NKDC submissions at Deadline 3 include our Oral Submission Summaries and responses to the ExA's Action Points from ISH2, 3 and 4.

## Springwell Solar Farm – Written Submission of Oral Case to ISH2 from North Kesteven District Council (ID 20054501)

## Springwell Solar Farm – Written Submission of Oral case to ISH3 from North Kesteven District Council (ID 20054501)

## Springwell Solar Farm – Written Submission of Oral case to ISH4 from North Kesteven District Council (ID 20054501)

TITLE:
FIGURE 3.11A
VEGETATION REMOVAL PARAMETERS
KEY PLAN

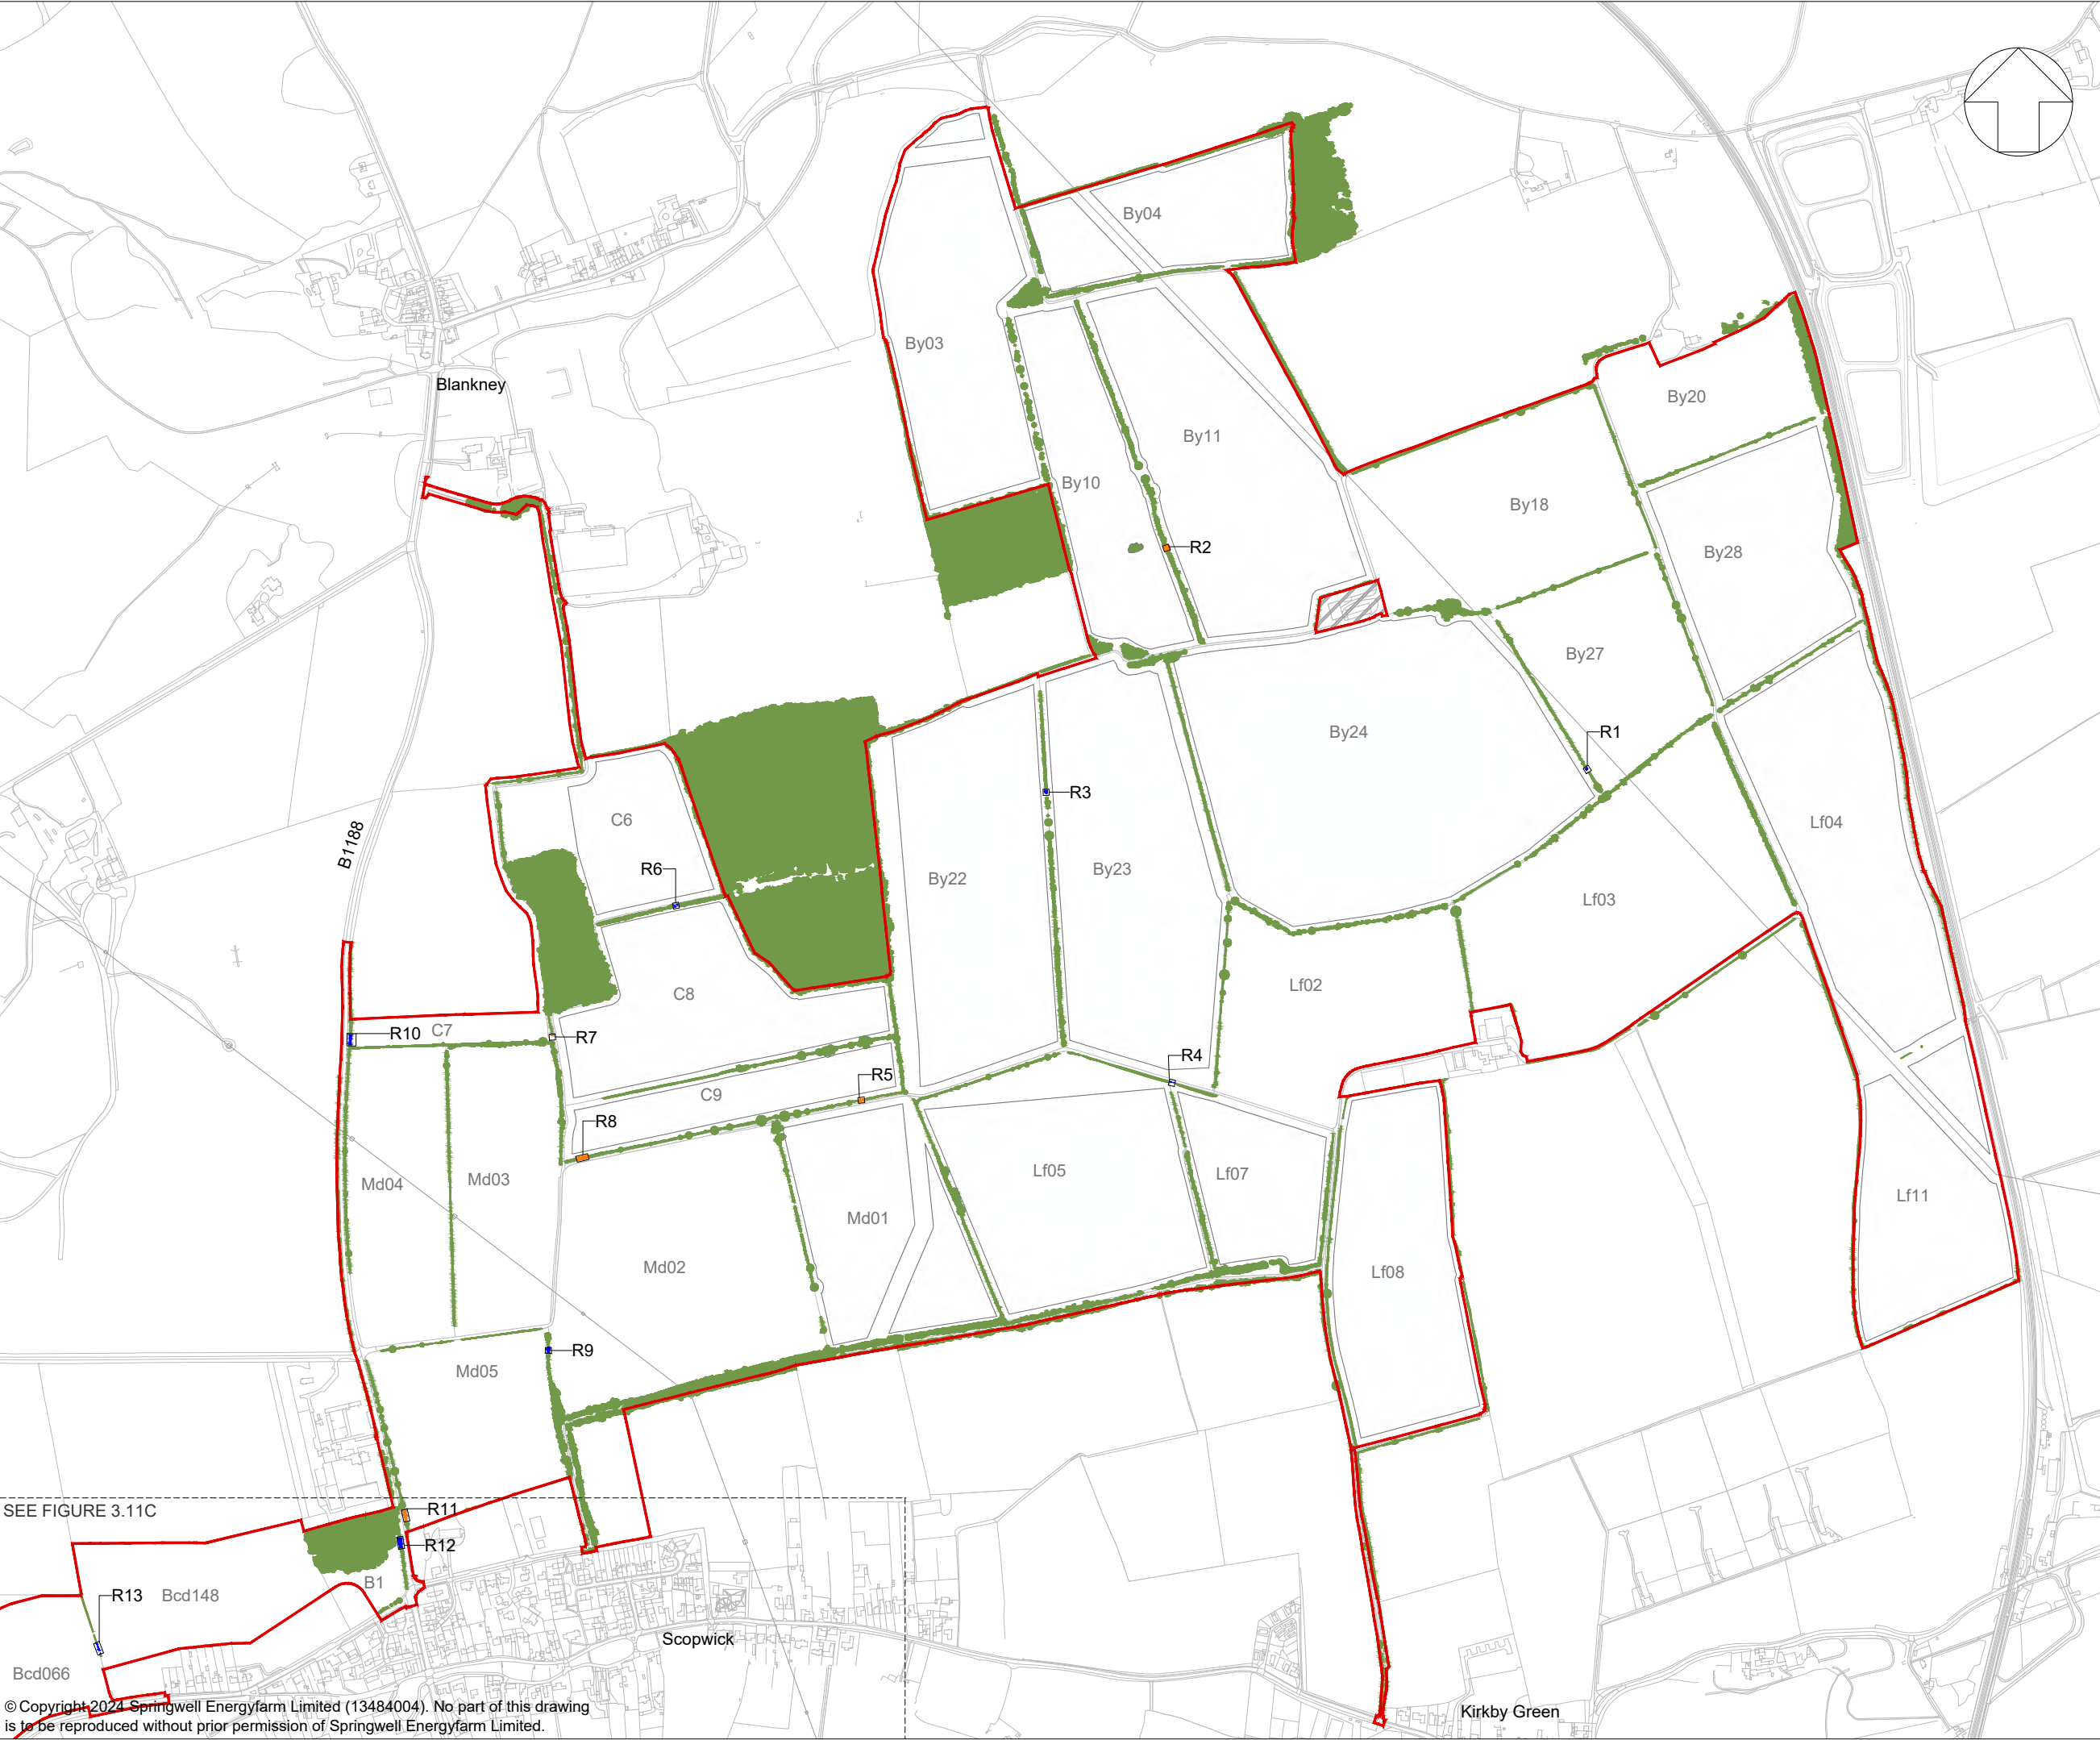
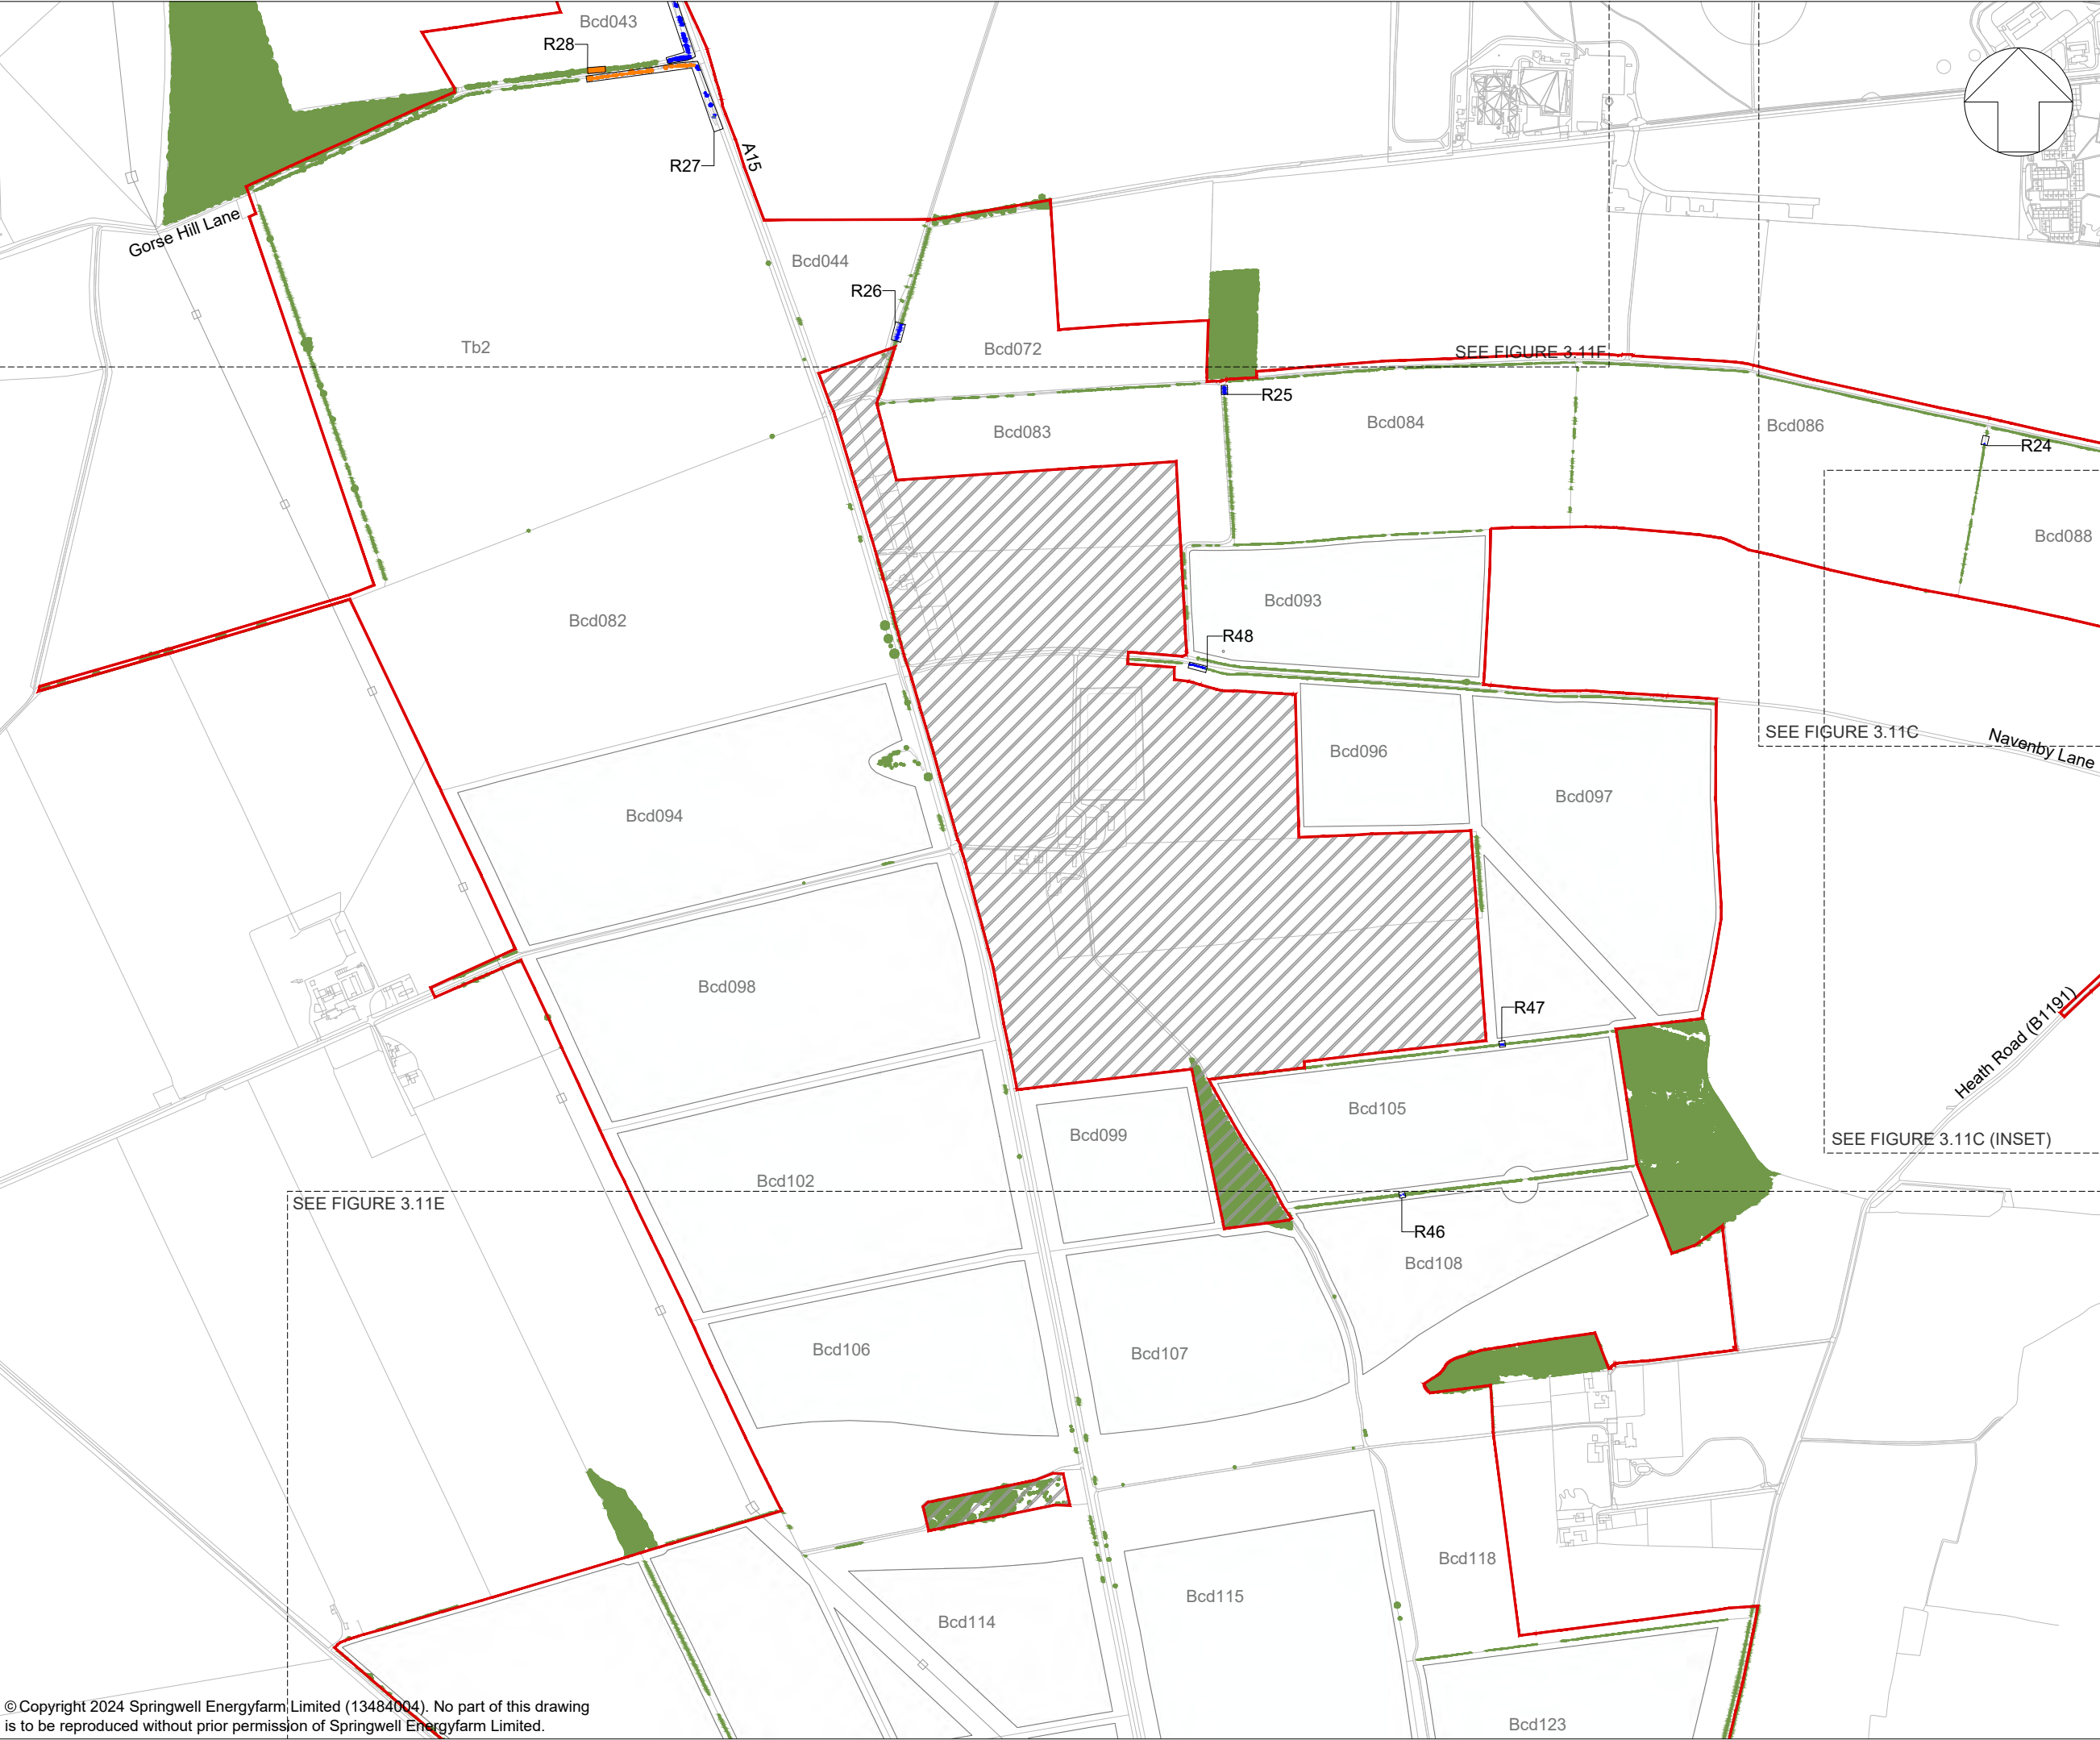
conservative estimate, this would equate to over 350,000 panels generating up to 200MW in Springwell East alone, which would still be classed as a very large scale solar scheme and well above the current threshold to be considered an NSIP.
<b>3.3 The Applicant will be asked questions relating to the vegetation removal parameters (Figures 3.11A to 3.11F) [REP1-027] and how landscape and visual impacts will be accounted for in finalising the location of vegetation removal.</b>	n/a
<b>Visual Impact and Design</b>  <b>3.4 The Applicant will be asked about the design process that is secured in the draft Development Consent Order and control documents.</b>	n/a
<b>3.5 North Kesteven District Council will be asked to expand on its concerns relating to the visual impact of highways components.</b>	<p><b>Submissions made by Oliver Brown, AAH Consultants on behalf of NKDC</b></p> <p>Under <b>Agenda Item 3.5</b>, in regard to concerns relating to the visual impact of highways components, localised removal of vegetation is identified in the assessment of landscape effects; however, at the time of writing our LVIA review it was unclear whether this included vegetation works on the wider highways network, and what this would entail. We have subsequently discussed this with the applicant at a recent meeting prior to the hearing, and they have now clarified the vegetation loss in the wider landscape, which takes account of anticipated highways and construction works including internal tracks, cable routes and the grid connection corridors. The location of vegetation removal is indicated by the Vegetation Removal Parameters</p>

<p>presented in Appendix 2 of the oLEMP [REP1-064] and these same figures are included as Figures 3.11A-3.11F of ES Volume 2, Figures, Chapter 3 [REP1-027].</p> <p>Should the DCO be granted consent, detailed LEMP(s) will be produced for the Proposed Development in accordance with the DCO Requirement in Schedule 2 of the draft DCO [REP1-006]. The LEMP(s) would require approval by the relevant planning authority prior to commencement of construction and would be required to be substantially in accordance with the framework set out in the OLEMP [REP1-064], including the Green Infrastructure Parameters presented in Appendix 1 and Vegetation Removal Parameters presented in Appendix 2.</p>
<b>3.6 The Applicant will be asked questions relating to the impact of glint and glare prior to Year 10 of operation and the visual impact of any temporary mitigation prior to the establishment of screening planting.</b>	n/a
